Please ask for: Sian Eggington
Email: sian.eggington@terraquest.co.uk
Telephone: 0121 2341390
Our Ref: AW/150/21/HH
Your Ref:
Date: 23rd April 2021

Application for Planning Permission for Works or Extension to a Dwelling

Development: To take down existing garage and garden wall and rebuild the garage, with a slight extension of 1m. Also to rebuild the garden wall. Replace existing cladding to elevation A.
Location: 6 Trinity Way Aldwick PO21 5RQ

# 6 Trinity Way

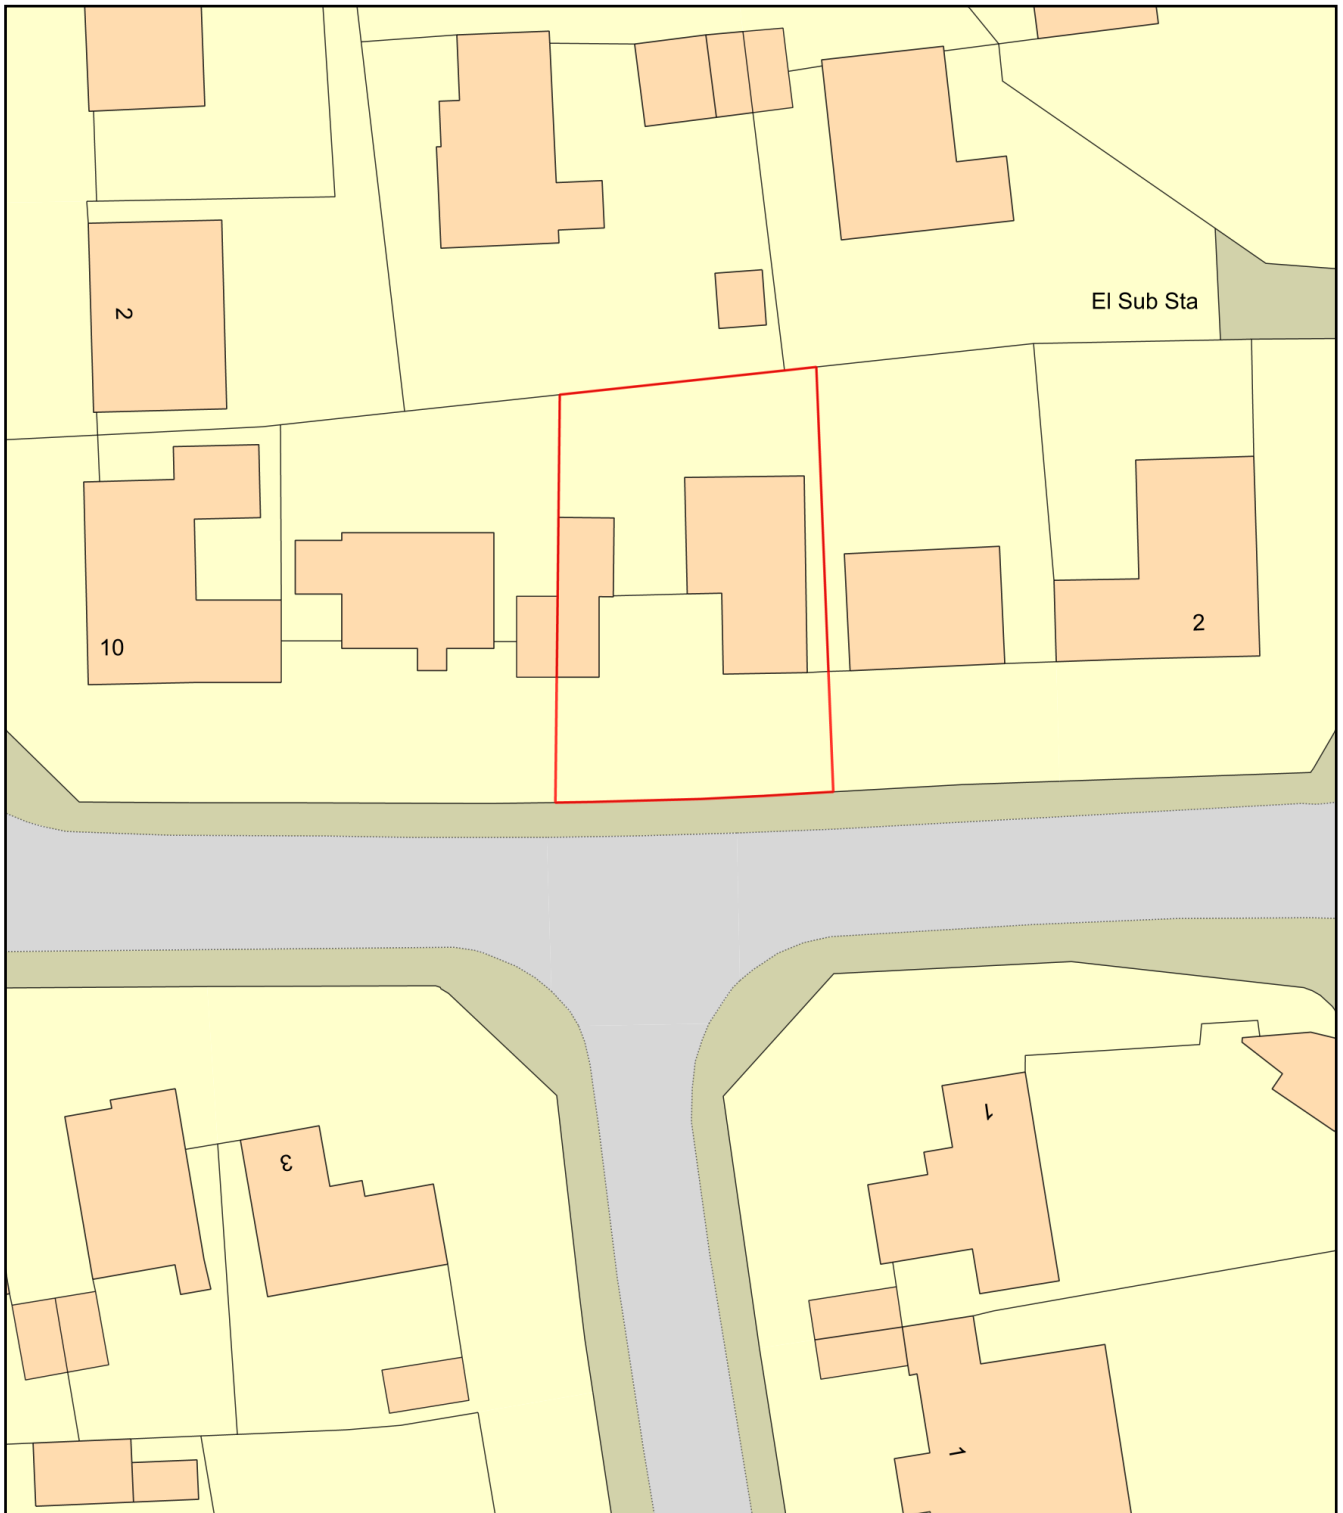
Block Plan

You are required to provide a proposed block plan with dimensions from the proposed extension(s) to all site boundaries. Please amend.
